2024/0139

Address: 31 Howard Street, Darfield, Barnsley, S73 9JD

Description: 2 storey side extension to semi-detached dwelling.

PROPOSED EAST (FRONT) & NORTH ELEVATIONS			
Date	11.12.2023	Scale @ A3	No. 09A
By	JL	1:100	
Drwg ref:	31HowardStreetExistingEastAndNorthElevationsV3

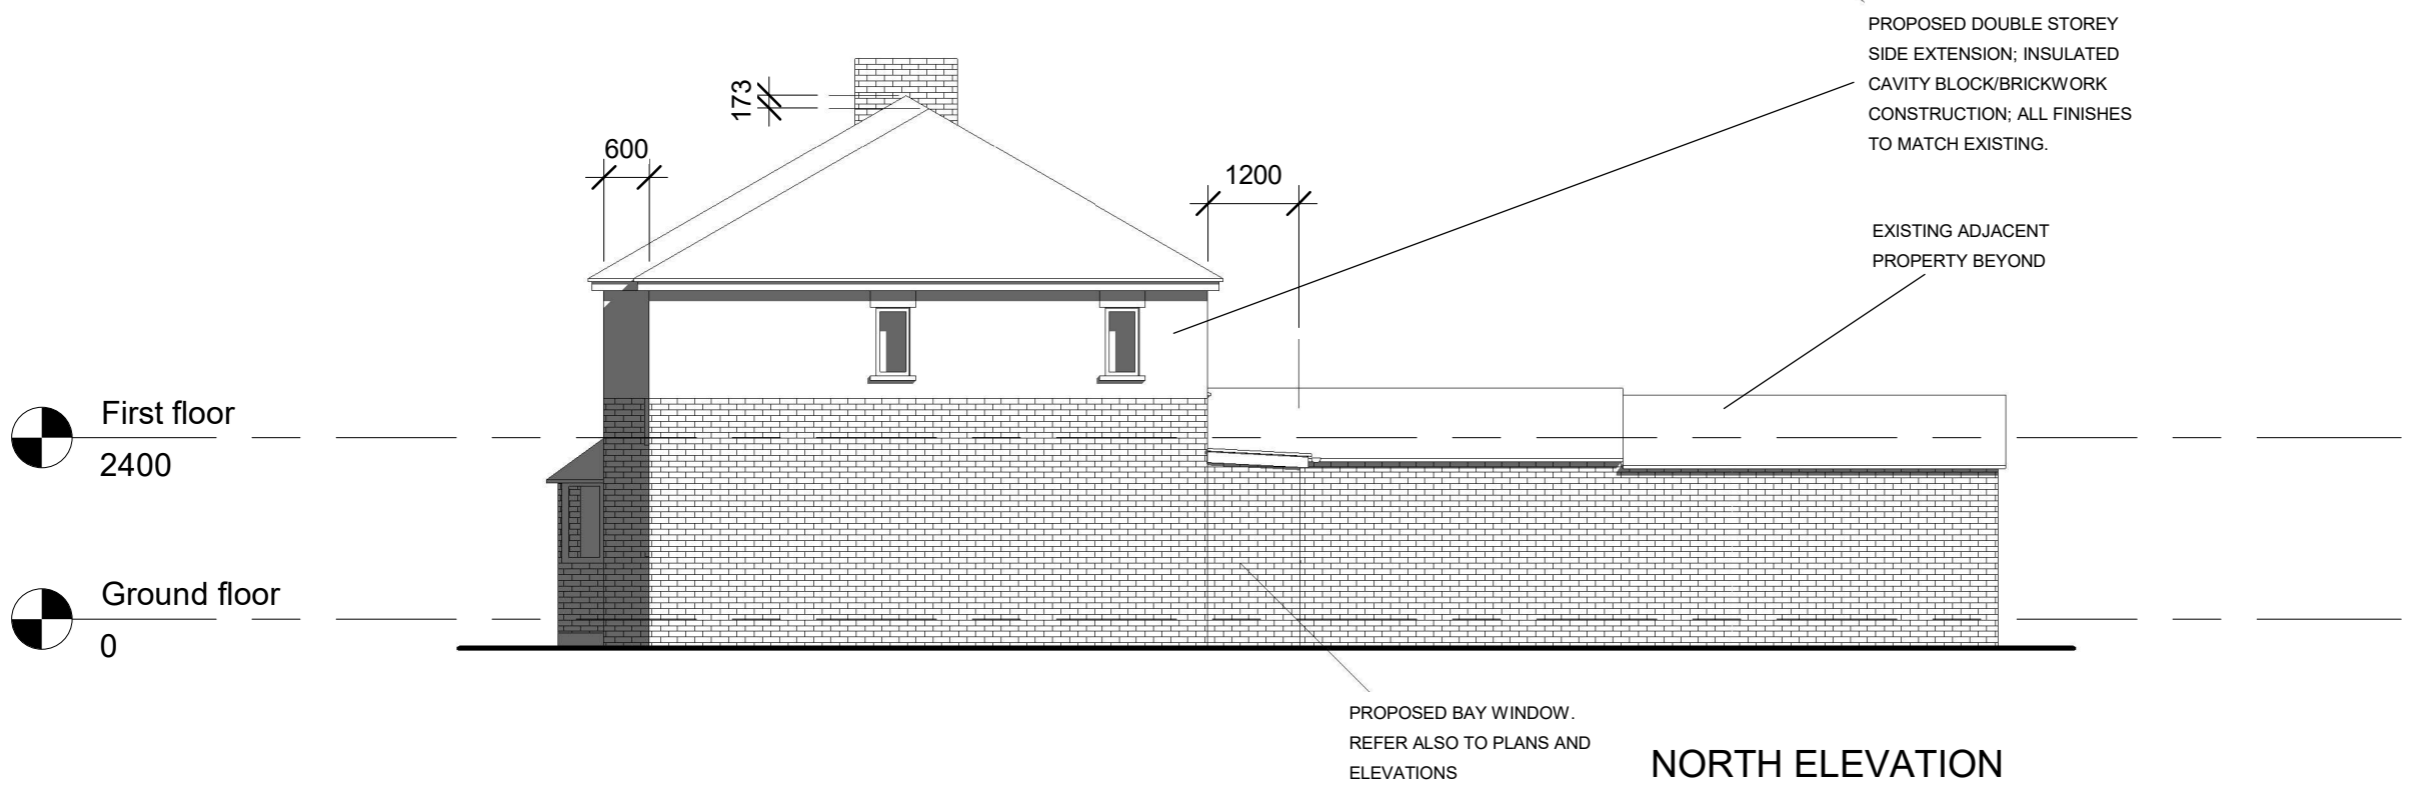
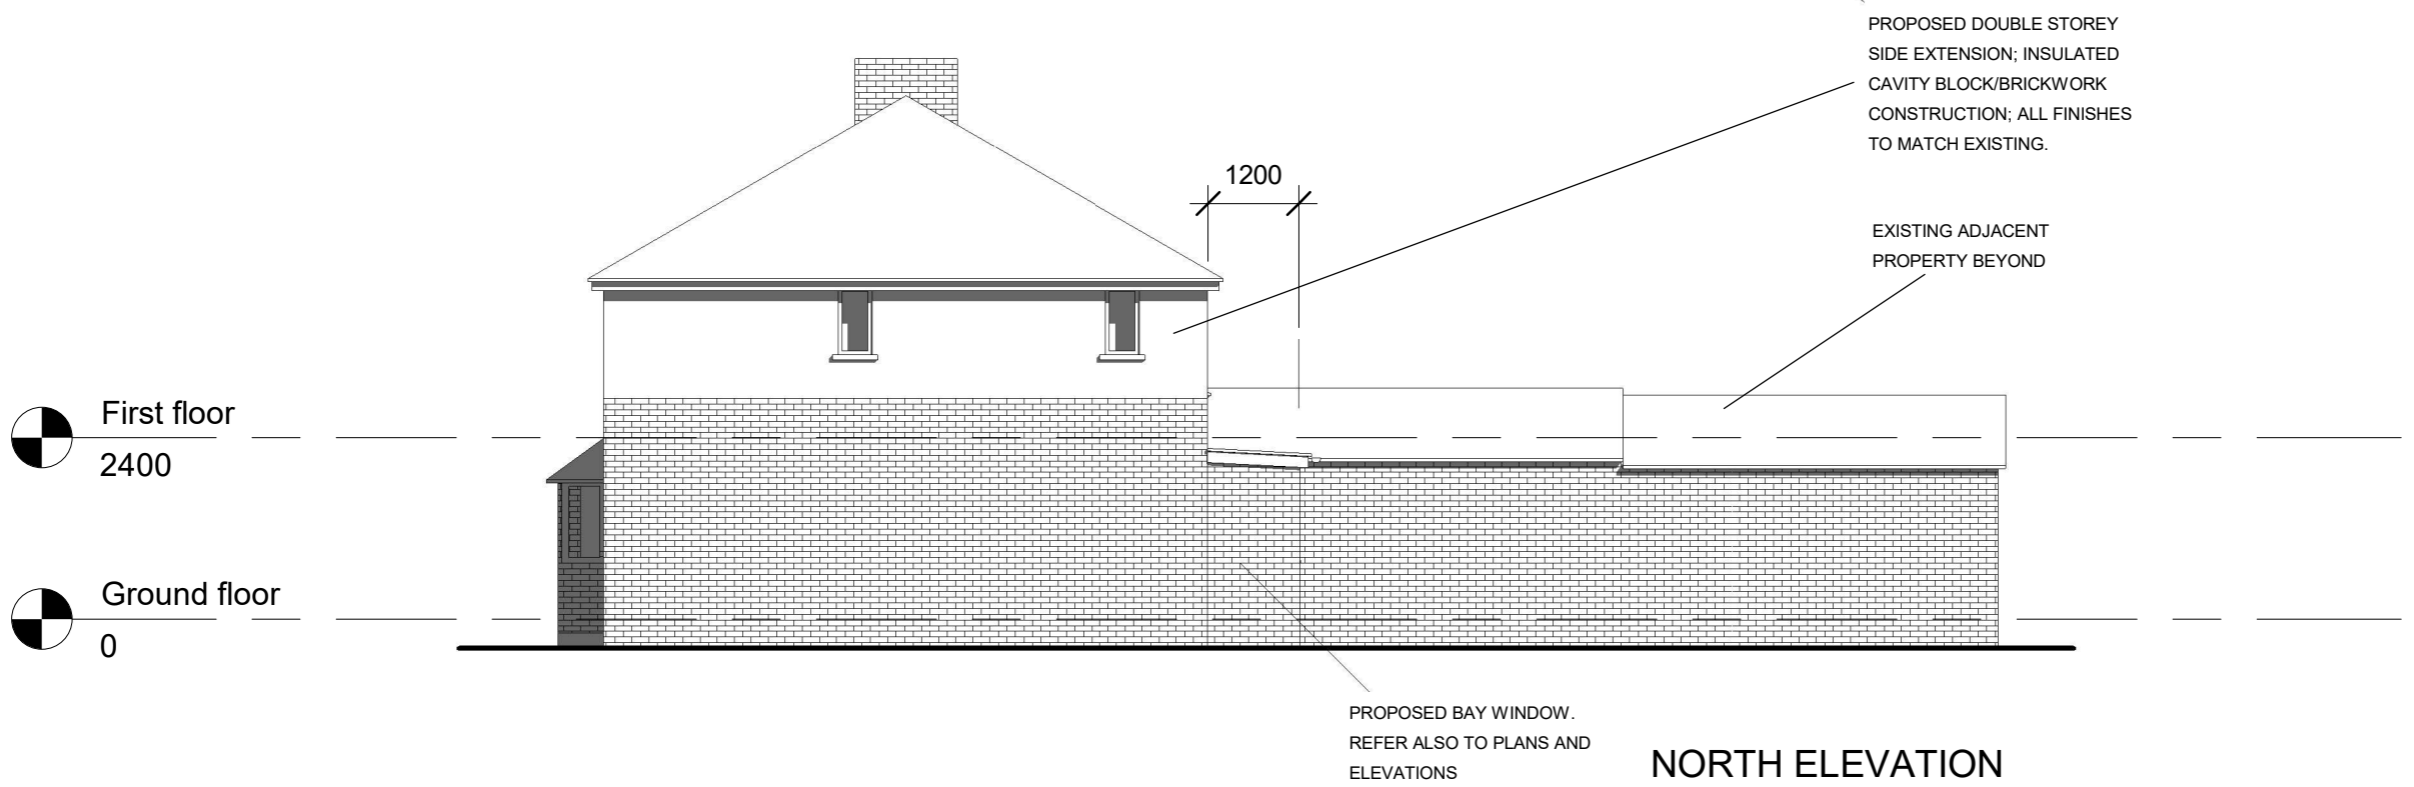
The proposal is for a two-storey side extension, constructed of matching materials and featuring a complementary styled roof. The proposal has been amended to meet local policy requirements of a set back and set down of for two-storey side extensions. At the rear of the ground floor aspect is what is described as a bay window, although it may be more akin to a small single-story extension or porch.

- **Side Projection: 2.24m**
- **Rear Projection (beyond rear wall): 1.2m**
- **Ground Floor Length (Inc. rear projection): 8.61m (7.99m)**
- **Maximum Eaves Height: 4.74m (4.74m)**
- **Maximum roof height: 7.11m (7.32m)**
- **Front Set Back: 0.6m**

With the required set back and set down of the proposed extension, combined with the use of matching materials and a complementary roof, the proposal would not significantly alter the character of the dwelling. With some similar, and arguably less aesthetically complementary to the street scene, the proposal would not be out of character and would do no harm to the visual amenity of the street scene.

PROPOSED WEST (REAR) & SOUTH ELEVATIONS

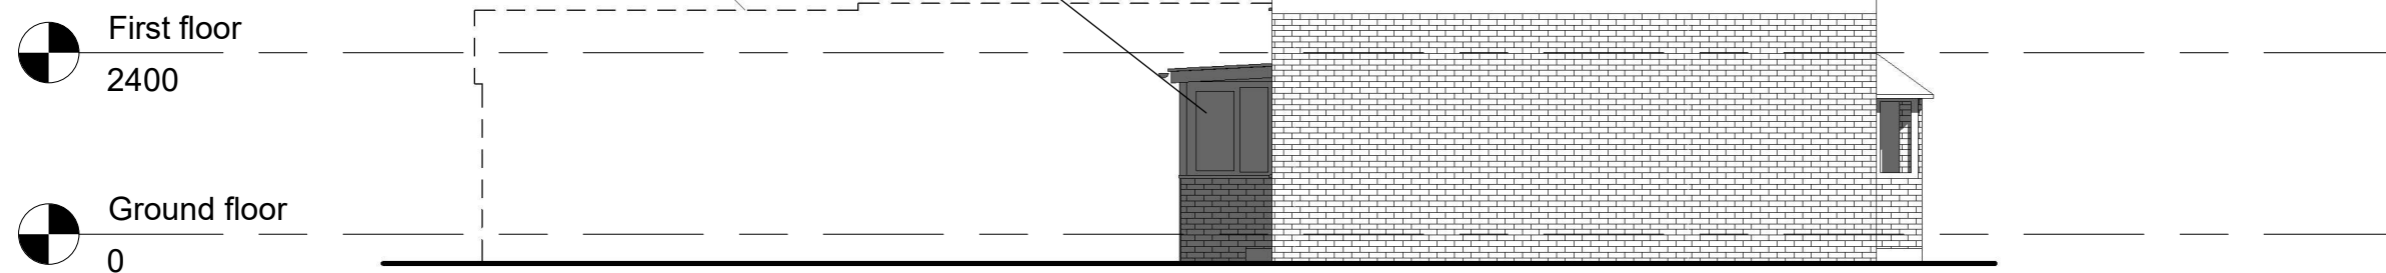
The proposal would be unlikely to have any impact on the residential amenity of the neighbouring dwellings or on other dwellings on the street. There is a reasonable distance between the application dwelling and the unattached neighbouring dwelling, with the houses angled away from each other, as the road curves around. There are two first story windows on the proposed extension, but both windows are small and are for non-habitable rooms of a bathroom, and a walk-in closet, with the closet being too small to be utilized as a bedroom. There are no windows on the ground floor side elevation, and the proposed bay window would have a minimum distance of 21m to the rear boundary.
